Consultee Comment for planning application 19/01746/OUT

Application Number	19/01746/OUT
Location	Land Adj To Promised Land Farm Wendlebury Road Chesterton
Proposal	Outline planning application (with all matters reserved excluding access) for up to 10,200sqm of B1 development (B1a and/or B1b and/or B1c); access and associated landscaping and infrastructure works
Case Officer	Clare O'Hanlon
Organisation	Clerk to Chesterton PC
Name	Jackie Williams
Address	Chesterton Community Centre 2 Geminus Road Chesterton Bicester OX26 1BJ
Type of Comment	Comment
Type	
Comments	See attached document.
Received Date	30/10/2019 21:35:09
Attachments	The following files have been uploaded: CPC Response to Catalyst Bicester Application.pdf

CHESTERTON PARISH COUNCIL'S RESPONSE TO CATALYST BICESTER
APPLICATIONS: 19/01746/OUT & 19/01740/HYBRID

Figure 2 Walking catchment (based on currently available routes)

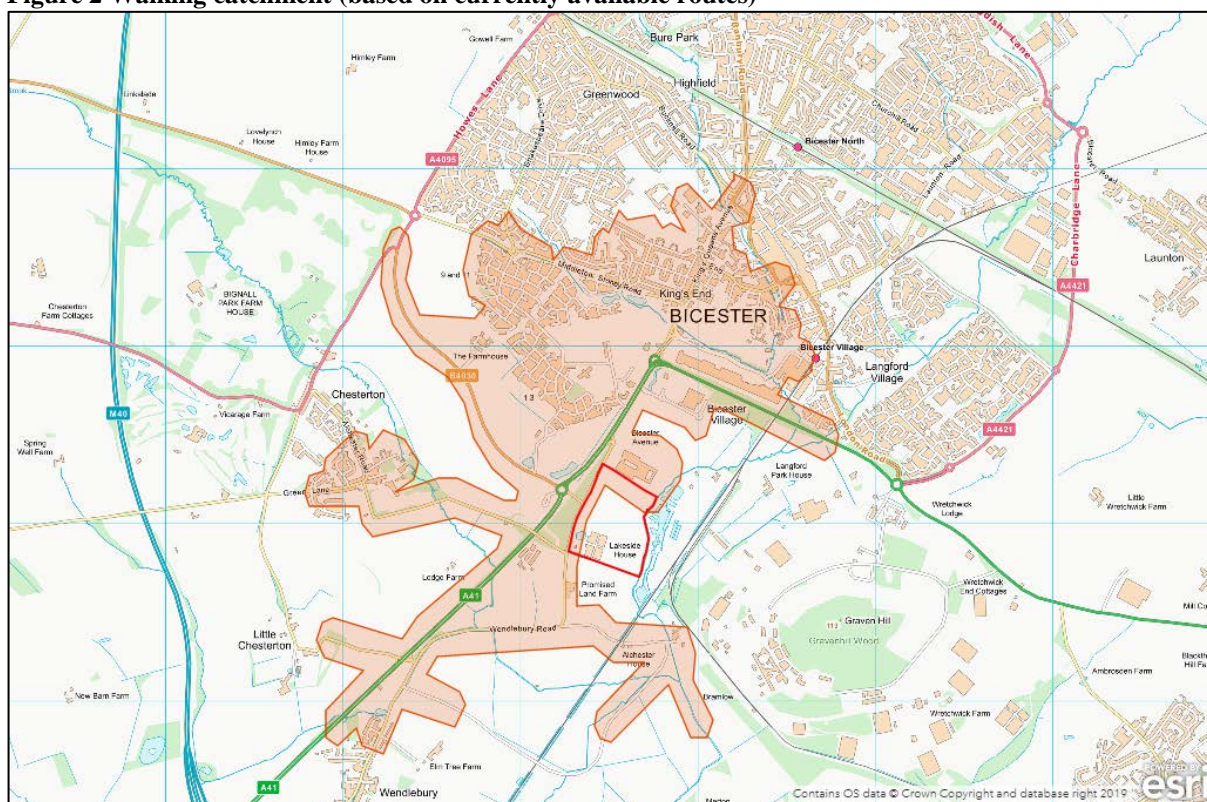
The walking catchment is a good idea in principle, but will it materialise in practice? Will measures really be implemented to encourage and monitor this aspiration?

Figure 3 5km Cycling catchment (based on existing routes)

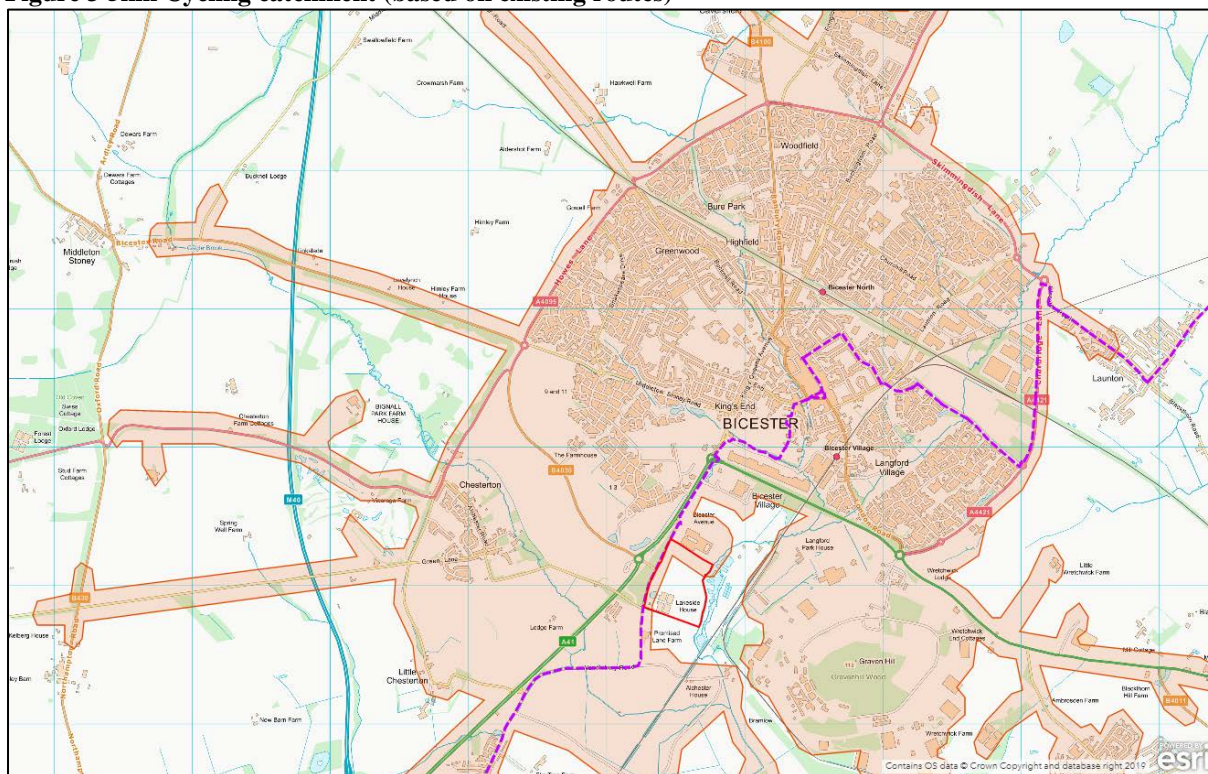
The cycling routes are interesting, including the A4095 towards Chesterton. However, the speed limit for most of this section is 60pmh and can be very dangerous for cyclists where no cycle track is provided yet would be needed should cycle traffic increase.

Figure 8.3 – New Roundabout Junction

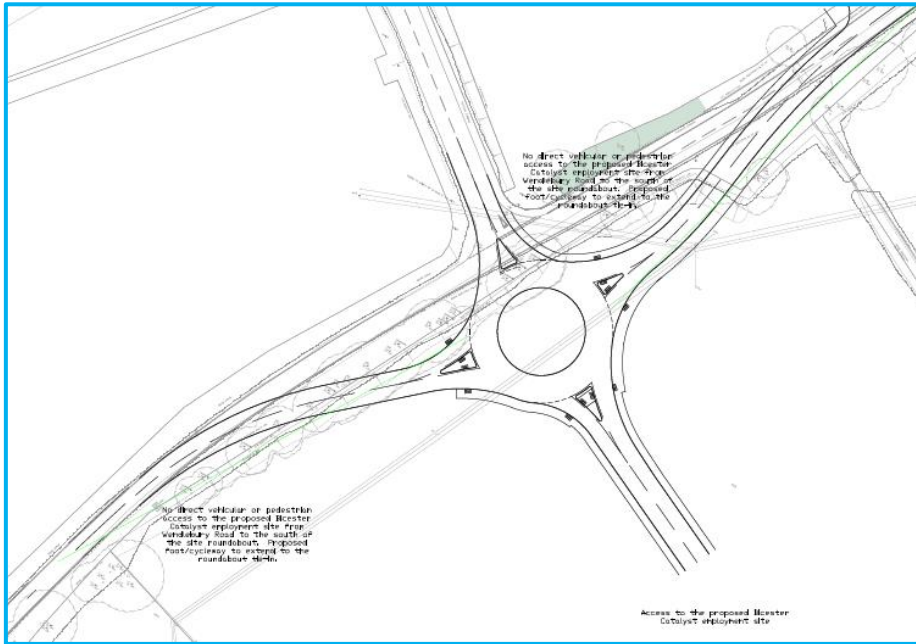
b. Devpt of Site Point 4: Inclusive new roundabout junction on Wendlebury Road and Internal Access Roads. Potentially dangerous if access from the bridge onto Wendlebury Road is not widened for better visual splay. Potential need for traffic lights on this roundabout as access traffic will not need to stop and Chesterton traffic will not be able to get onto road. Will the proximity of this proposed new roundabout to the existing Vendee Drive roundabout not impact on traffic on the A41?
